Approval of details reserved by condition imposed under ref K/40/18/PL relating to Condition No 5 - schedule of materials & finishes.

Spring Tide Gorse Avenue East Preston BN16 1SF

Arun District Council have decided to **APPROVE details reserved by this condition**

Drawing: DOC - Materials
ST - OBA - 00 - ZZ - DR - A - 0450 -
Status: Discharge Of Conditions OBA proj no: 247

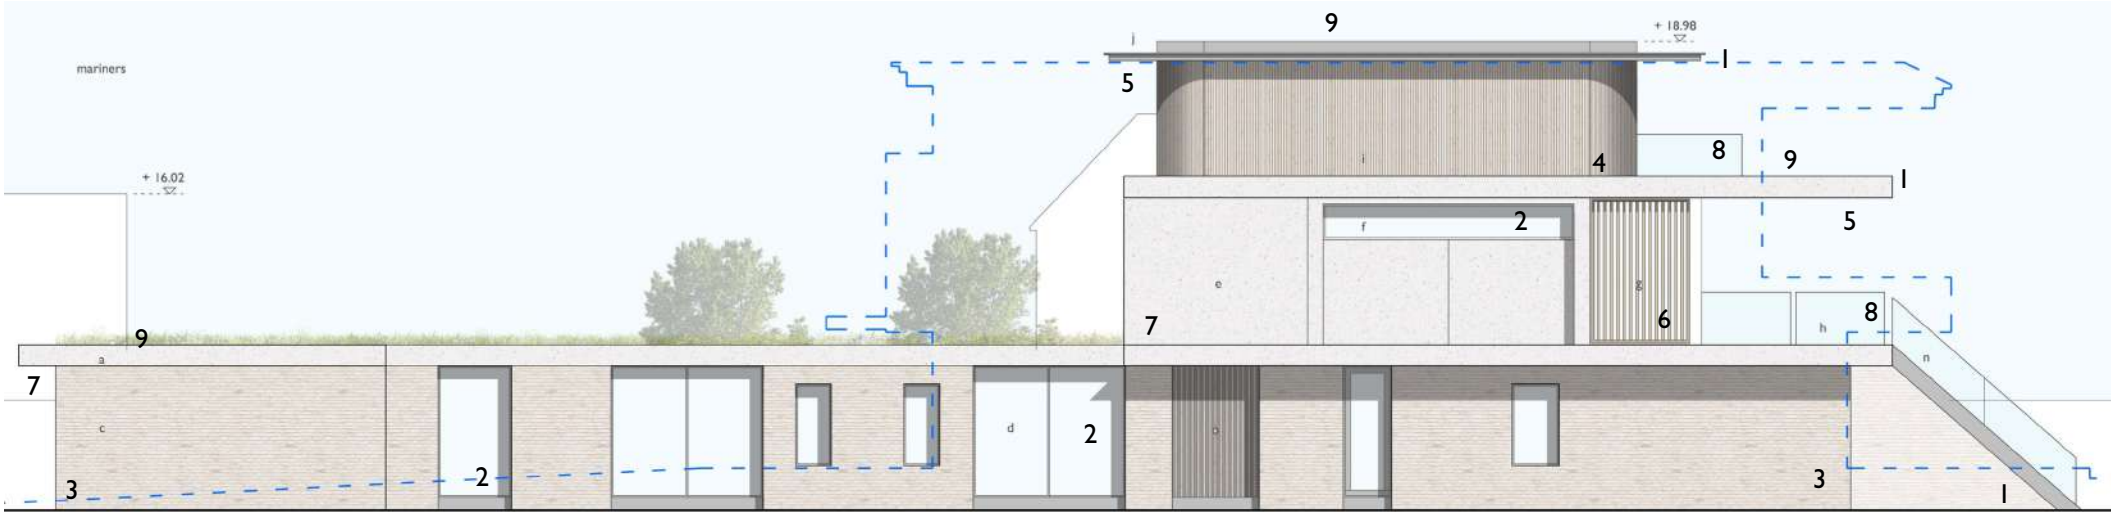
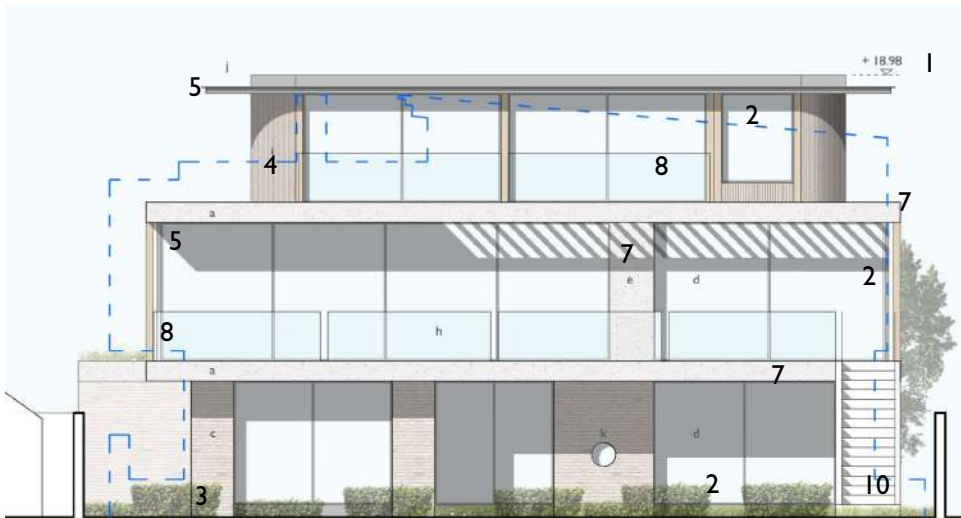
This condition is discharged in so far as submission of external walls and roof materials relates, but excludes Balustrade Details referred to on the plan which are not required to discharge this condition. This approval refers to the other details on drawing ST - OBA - 00 - ZZ - DR - A - 0450-23/04/2021- Discharge Of Conditions

Please note that details of balustrading are not included within this approval .
